Our Reference: SYD18/01322/60

Departments Reference: SSD 9522 MOD 3

AMMENDED APPLICATION - SECTION 4.55 (2) MODIFICATION TO PROPOSED WAREHOUSE & LOGISTICS HUB - 657-769 MAMRE ROAD - KEMPS CREEK - SSD 9522-MOD 2

**Figure 4.3. Bakers Lane, Future SLR and New Access Road Intersection Arrangement**

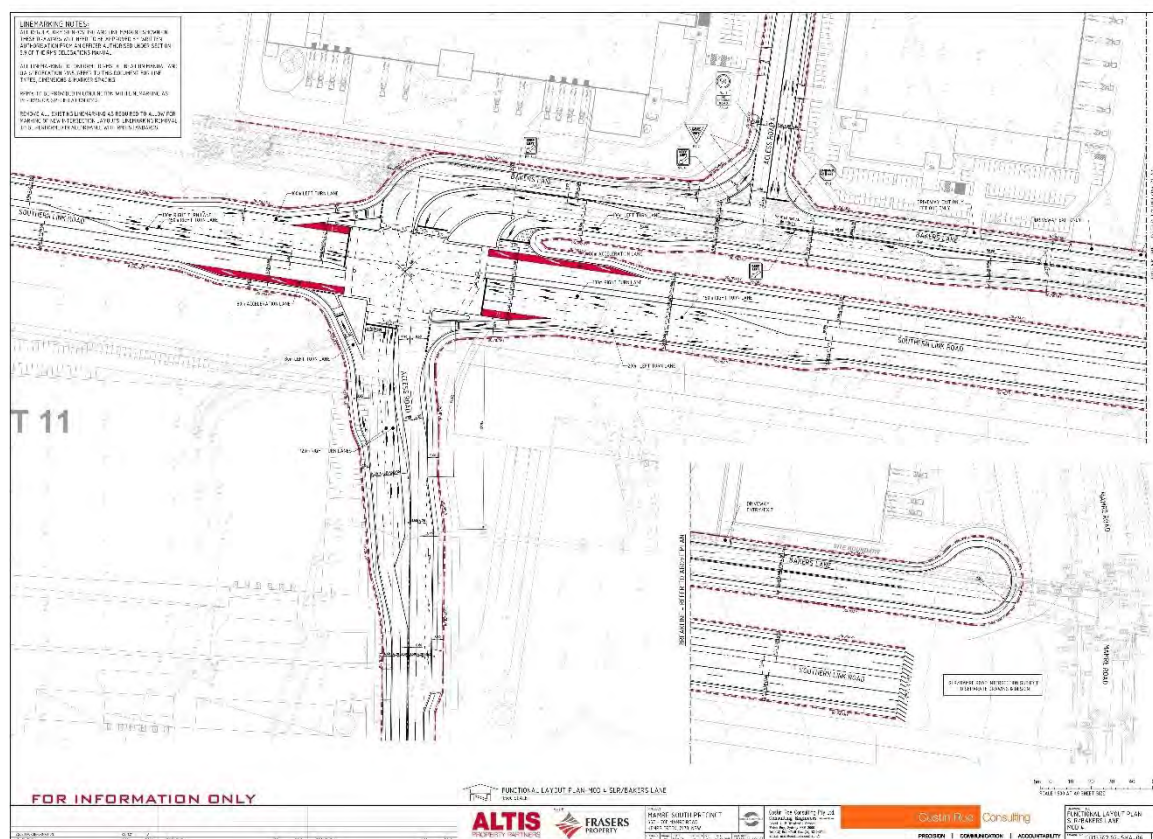
TfNSW notes the alignment offset of the access road (to Lots 1-4) creates significant geometric challenges for the future intersection of Southern Link Road (SLR) and north south access road (south of SLR) as shown in Figure 22 *Asongroup* Transport Assessment.

The future intersection of SLR and north south access road forms a future key intersection to the estate and is expected to be constructed to State Road standards. It is crucial the future intersection layout is supported by TfNSW to ensure adequate land setbacks are provided, and the interim access strategy can be achieved within the design. TfNSW notes the issues raised may be resolved by aligning the access road (to Lots 1-4) at the cross section of the intersection.

TfNSW recommends the alignment of the access road (to Lots 1-4) be relocated to align with the future intersection of the SLR and north south access road and the comments/suggestions provided in Attachment A are addressed for further review.

TUNNING PATHS PLAN-LOT 2 ACCESS
SCALE 1:300

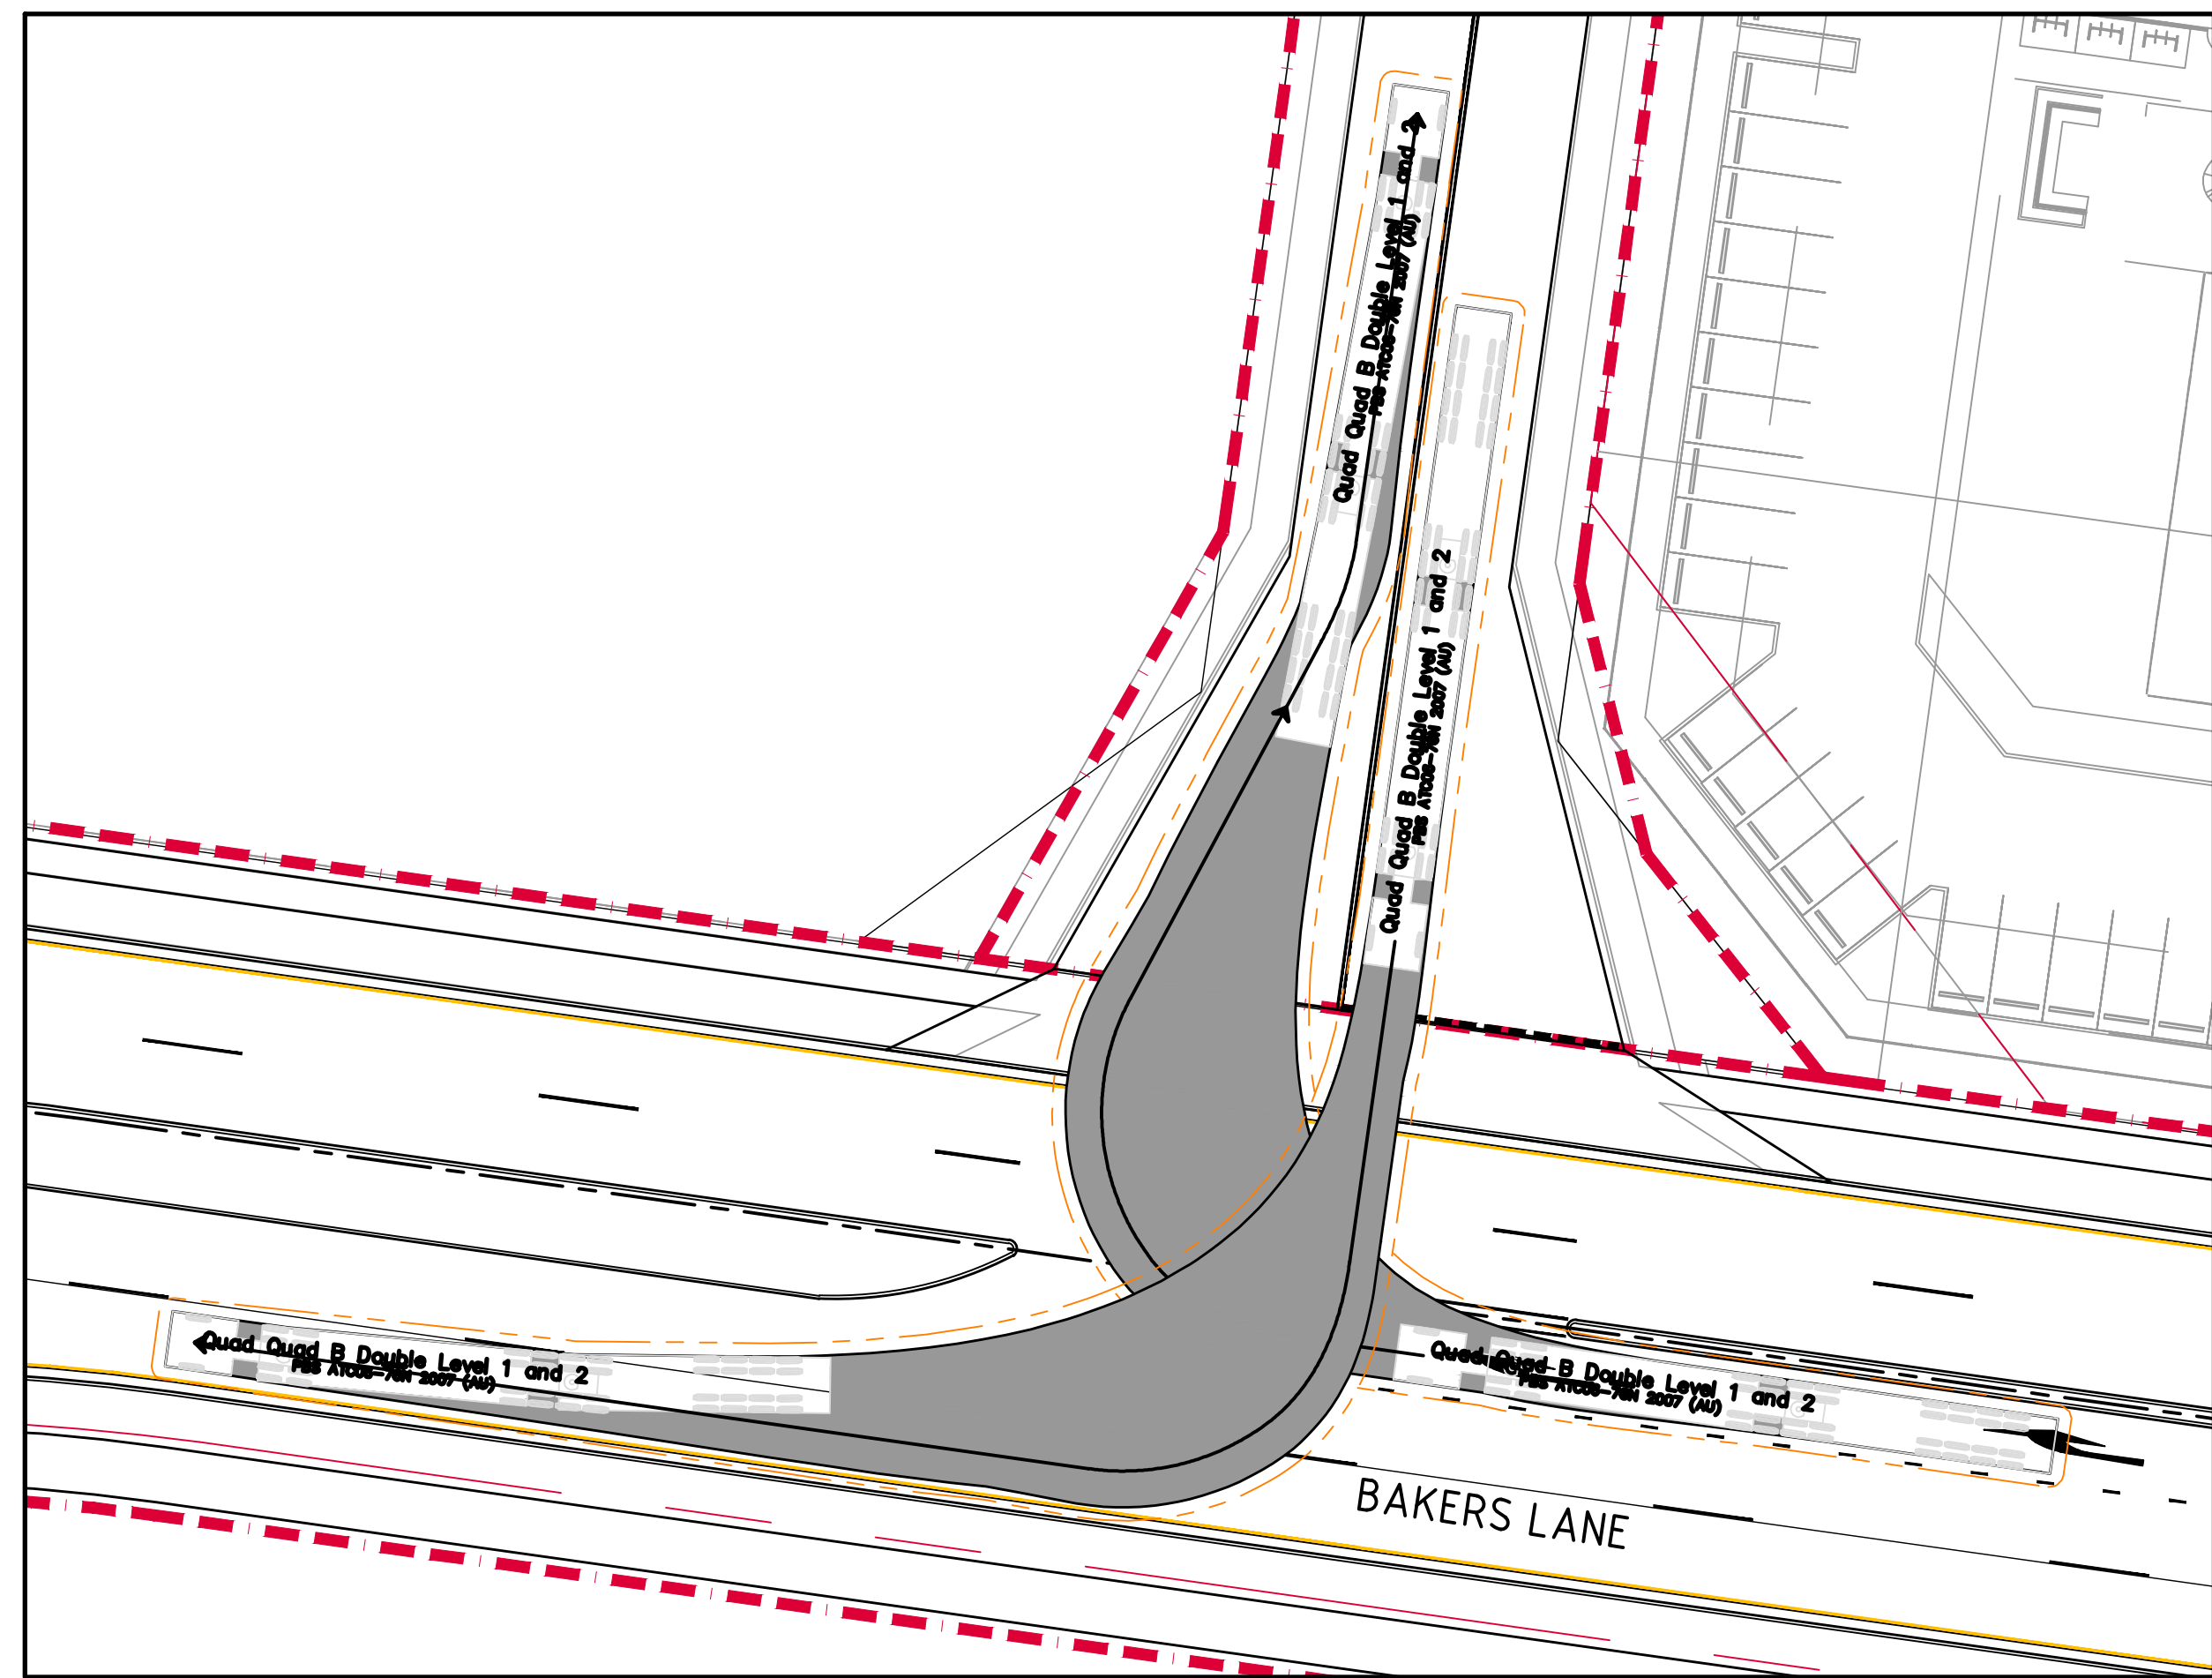
Items 3&4 Table 2 of the Traffic Report provides some commentary on the access points. TfNSW understands that the access/egress from Lot 2 at Bakers Lane is restricted to Left in/Left out which is supported. However there remains safety concerns with the closely spaced heavy vehicle exit and the entry/exit to the carpark.

In addition the swept path indicates a heavy vehicle would be required to swing from the western side of the driveway in order to achieve egress from the site. It is unclear how the driver know to do this.

It is recommended the applicant address the abovementioned concerns to the satisfaction of Council.
